27 April 2018

620.17901 L01 - v0.3 20180427 Traffic RtS.docx

Mirvac Projects Pty Ltd  
6001 (Bay 6) and 7006 (Bay 7)  
2 Locomotive Street  
Eveleigh NSW 2015

## **Locomotive Workshop Redevelopment | SSD 8157 and SSD 8449 Traffic and Transport Response to Agency Submission**

610.17901-SK09 Rev C

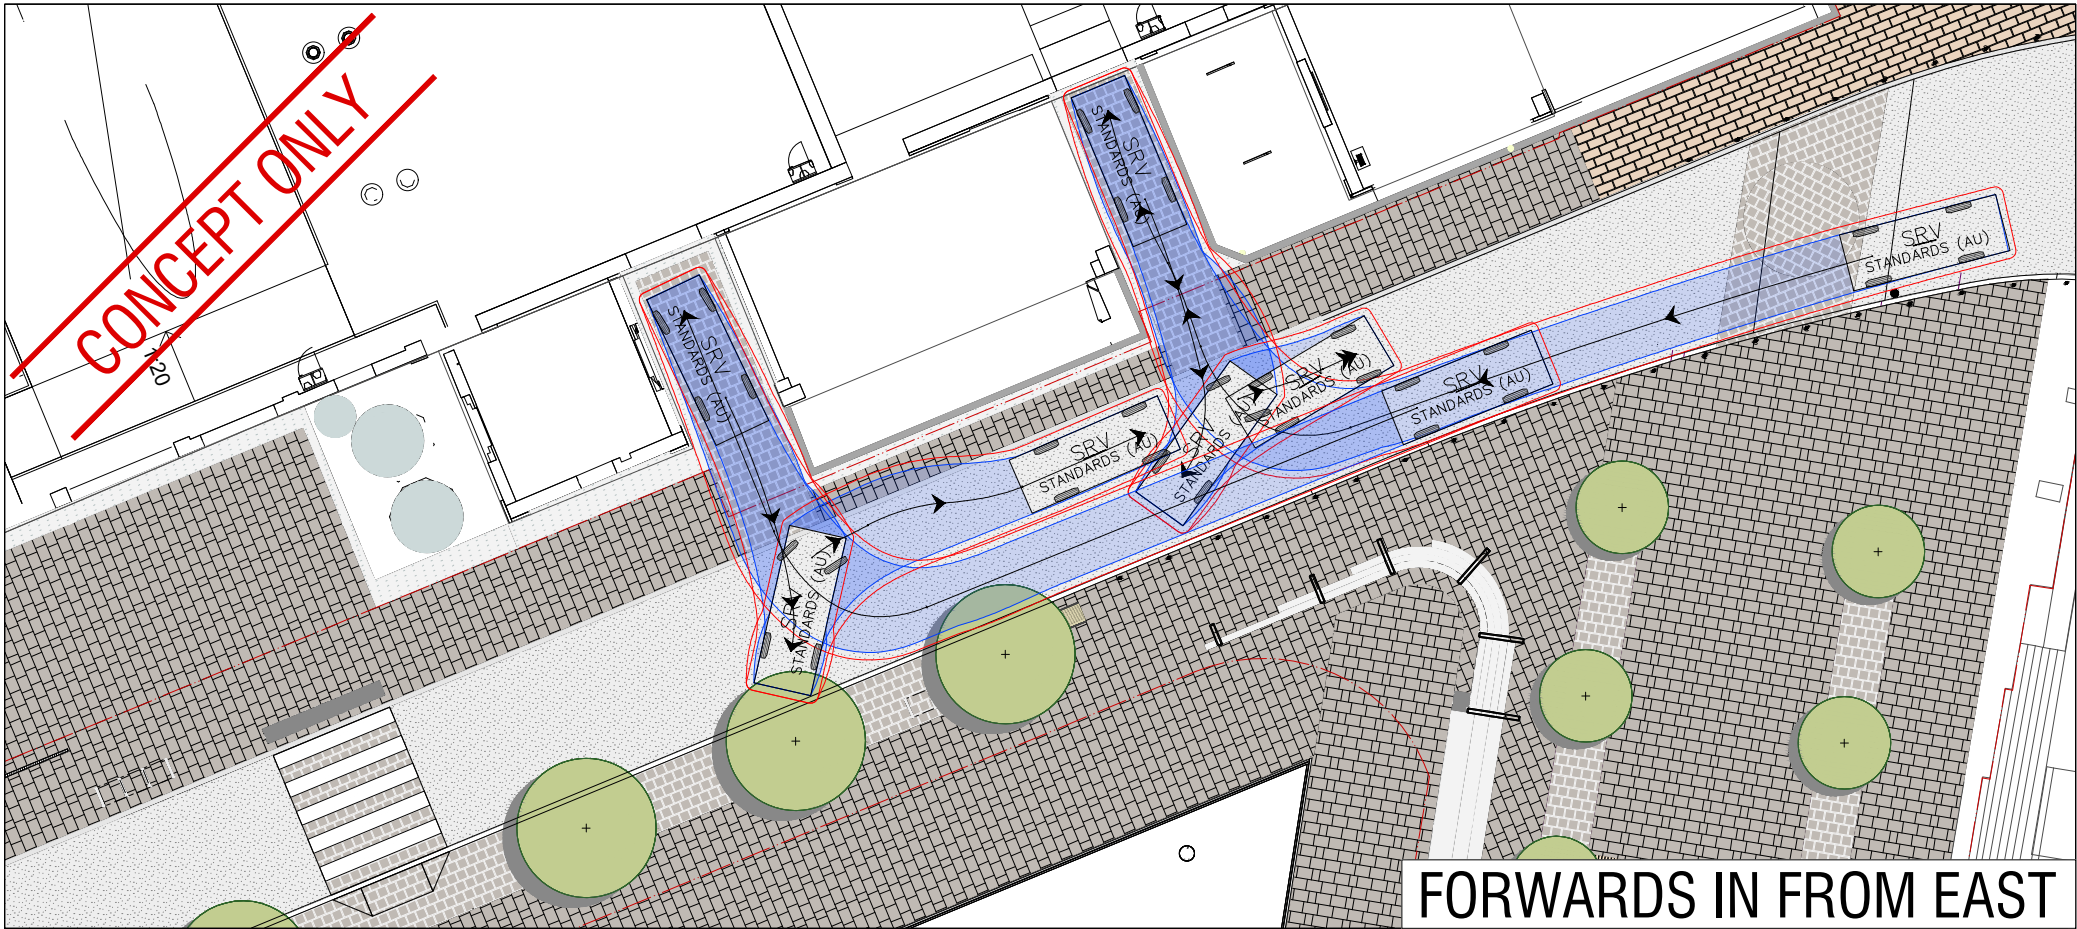
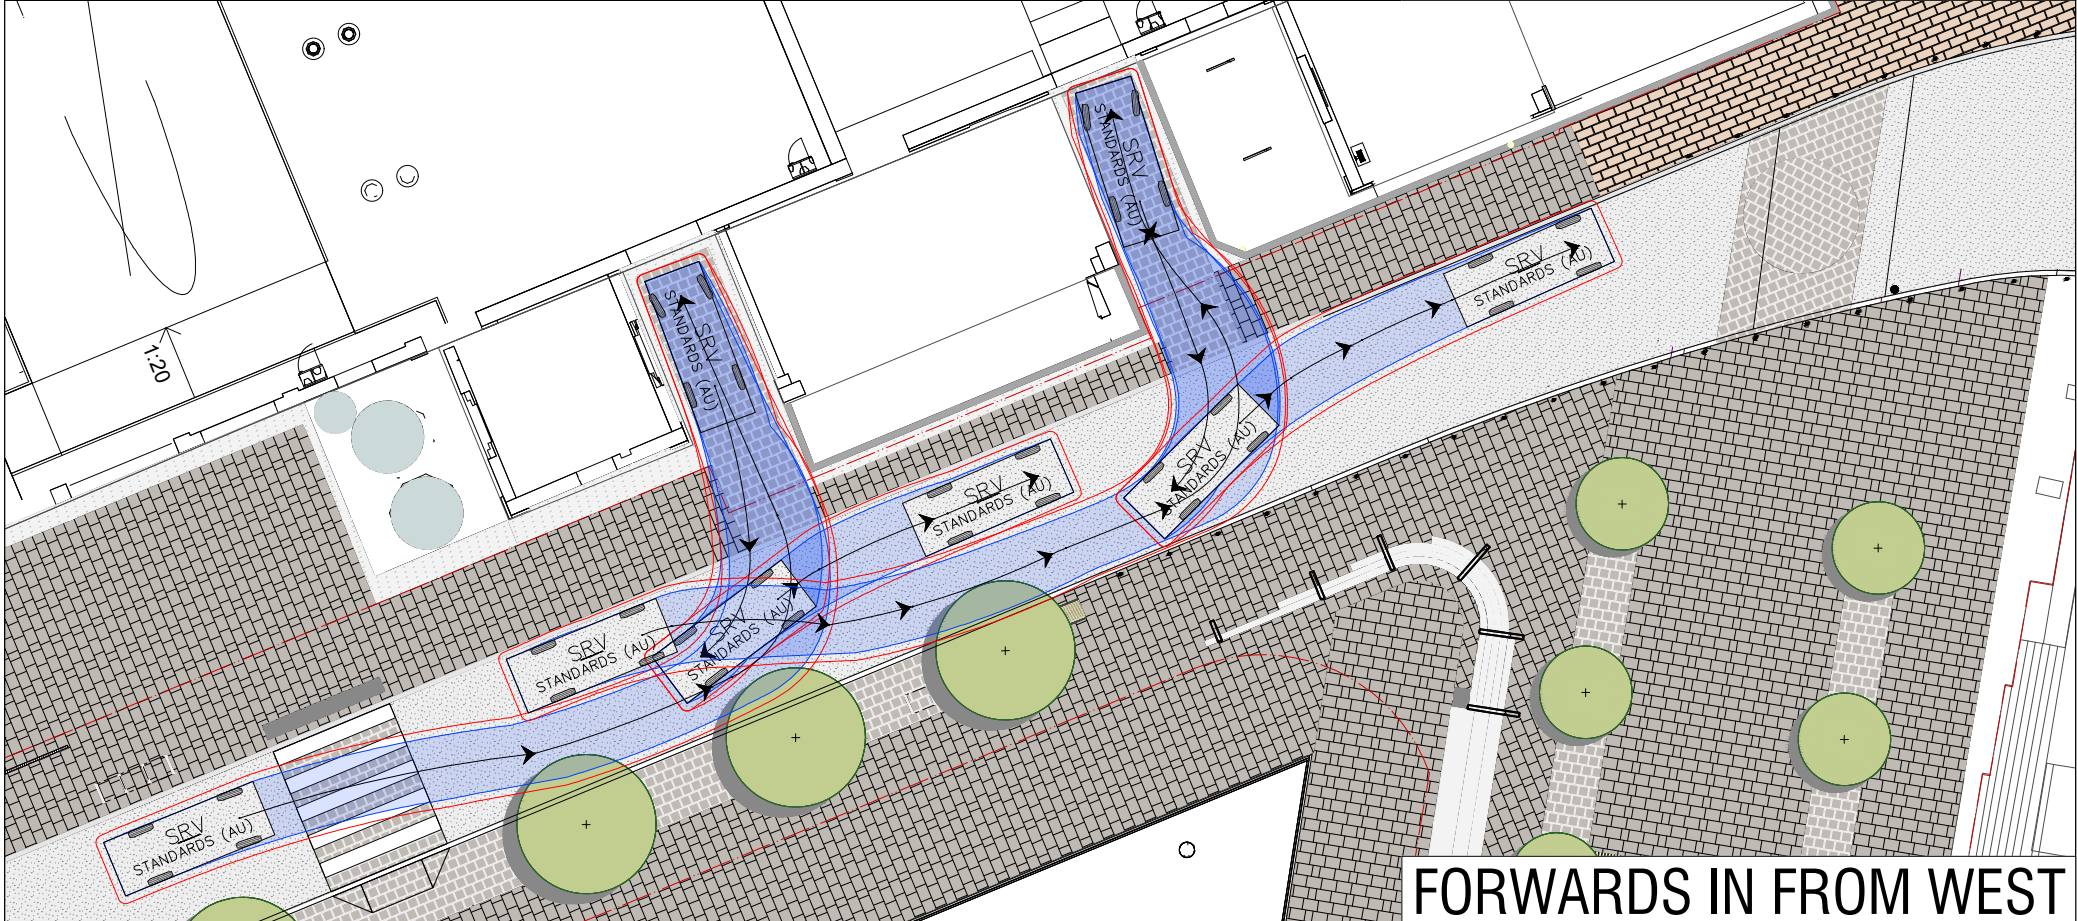
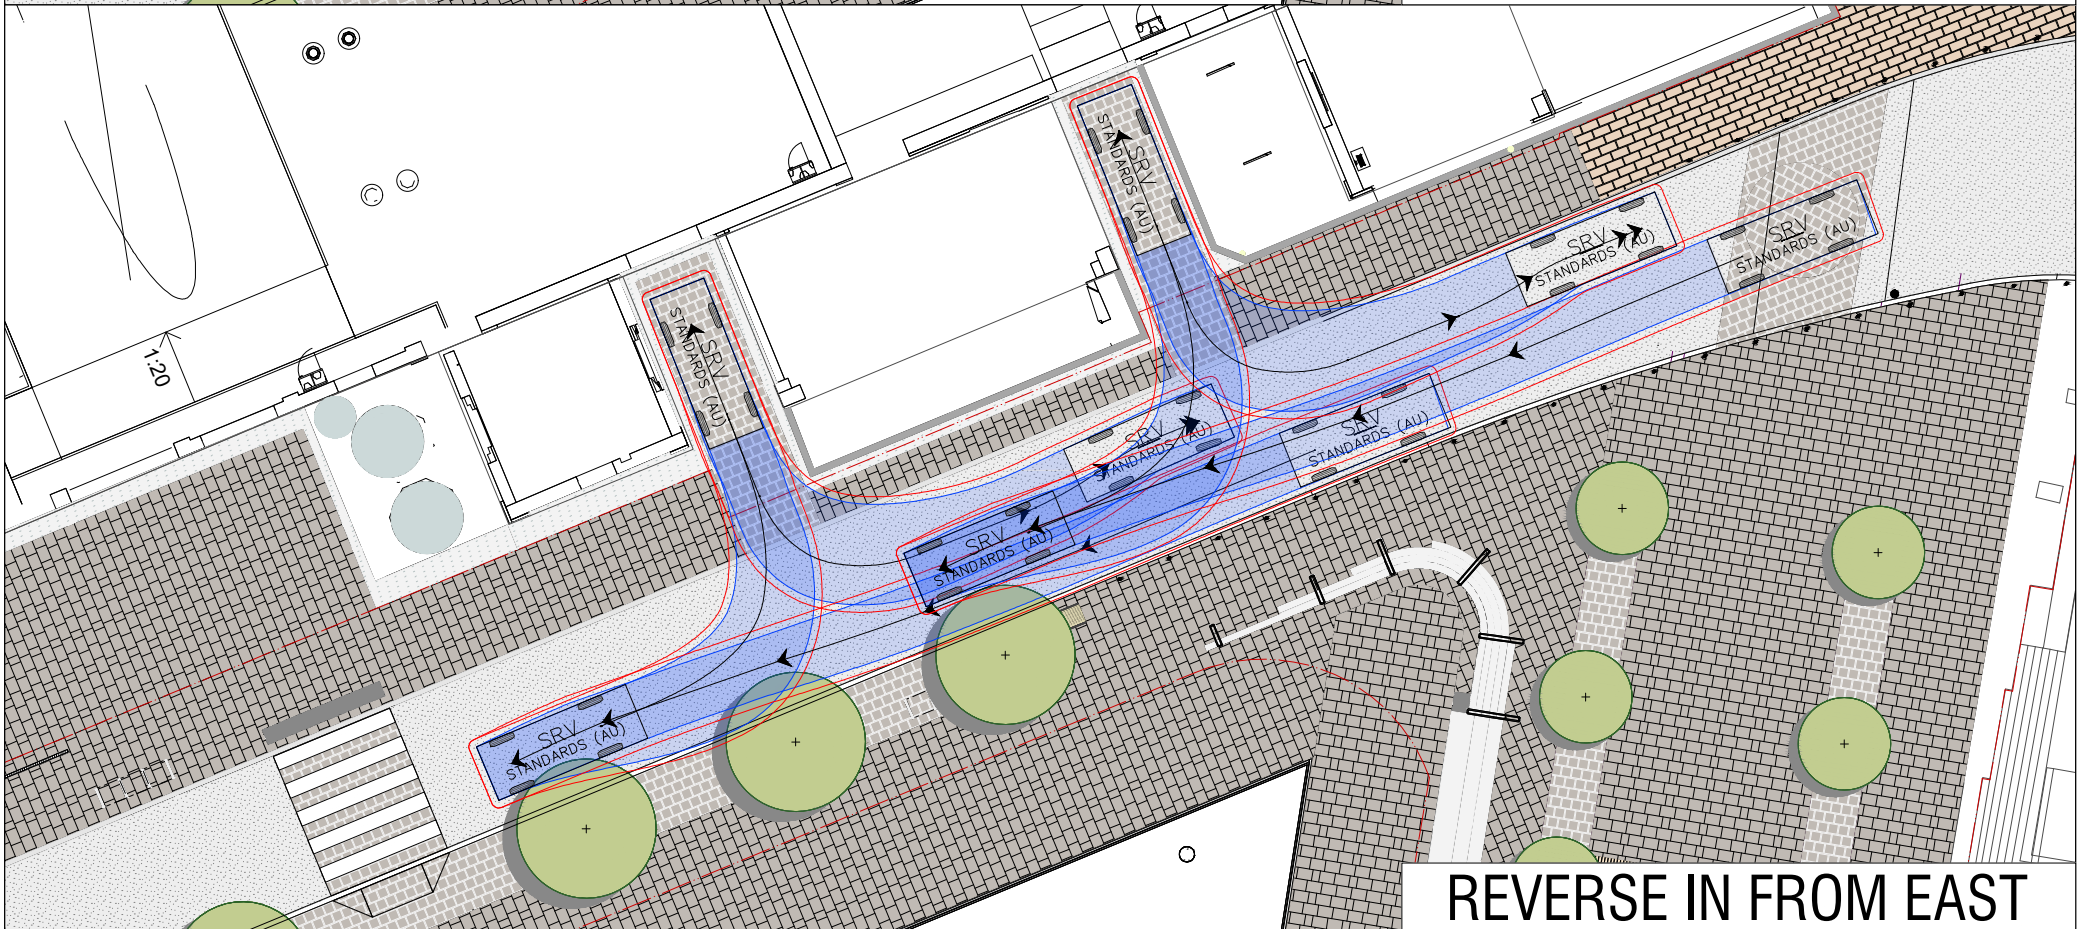
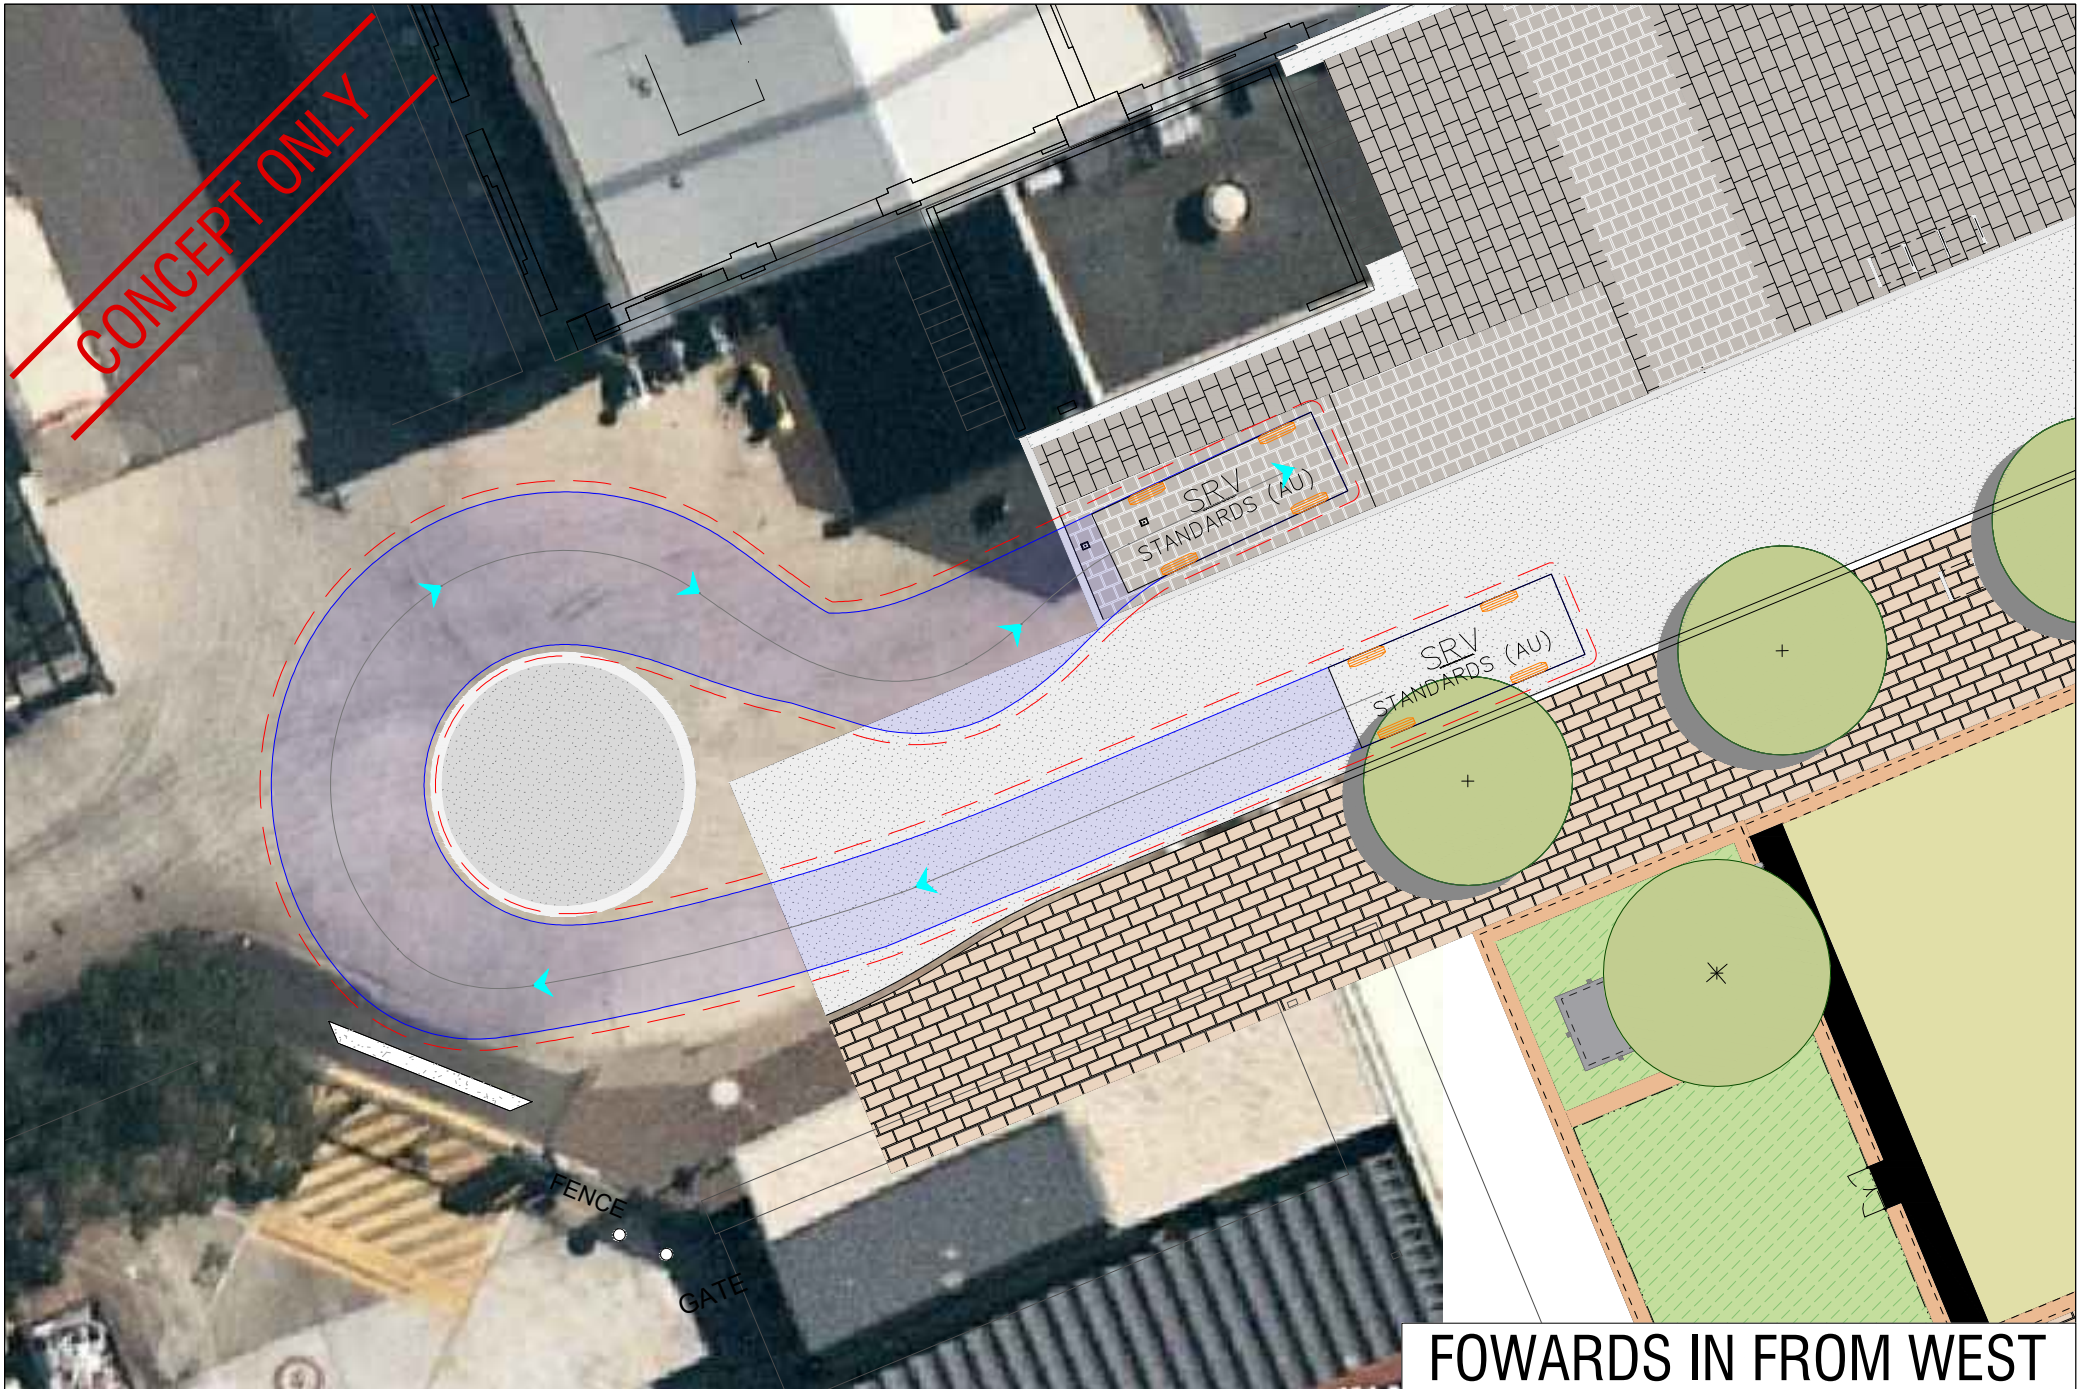
Within Innovation Plaza, trucks will enter in a forward gear, stop, and reverse into the subject loading dock. **610.17901.SK09** and **SK09B** show these arrangements for the RCV and LRV respectively. Potential conflicts between pedestrians and trucks in Innovation Plaza can be categorised as occurring in three segments when trucks:

Conflict type 2 involves the truck reversing into the proposed loading dock from a stopped position in Innovation Plaza. Whilst the specifics should be resolved as part of a Loading and Access Management Plan that can be imposed as a consideration of approval; this manoeuvre is considered acceptable based on the following:

The swept path plans confirm that one of the existing trees in Innovation Plaza will have to be removed to facilitate entry/exit to the loading dock. The impact on the remainder of the trees including partial conflict with canopies is limited. Additional detail is included in the arborist's Tree Removal and Pruning Application prepared by Hancock Consulting.

The previously submitted development plans have been revised such that the flexibility and internal scale of the service area and loading dock is improved. **610.17901.SK09** and **SK09B** show the swept path requirement for the two larger design vehicles manoeuvring within the loading dock area.

- Servicing movements can occur outside peak pedestrian demand periods
- Innovation Plaza incorporates physical landscaping and street furniture that has been designed to emphasise the desired walking route being central to Innovation Plaza. Devices and treatments are selected to passively shift pedestrians away from walking in close proximity to the loading dock entry
- Truck will be travelling at low speed and will be fitted with reversing claxons
- Pedestrians occupying the potential conflict area inside the truck turning circle will be visible to the driver from his driving position
- Drivers are likely to be regulars to the site and will be familiar with the locale and behaviours
- All users will have good observational sight distance to one another.

Of particular note, the service area can now accommodate at least two large trucks concurrently, i.e. two trucks can enter, stop/service, and exit clear of one another irrespective of their arrival and departure order. Concurrent loading/refuse collection was not previously possible with reference to the swept path plans prepared by GTA as part of the original SSDA.

The SLR swept paths confirm that the design vehicles can manoeuvre to, within, and from the service area with 0.6m clearances measured from the truck body. This clearance is double the 0.3m specified by AS2890.5 for low speed truck manoeuvring. Furthermore, the swept paths indicate that there is even more clearance or 'breathing space' available beyond the 0.6m clearance envelope. This is especially the case where trucks travel past the Davy Furnace and other heritage and building elements. The internal loading dock arrangements accord with that specified in AS2890.2.
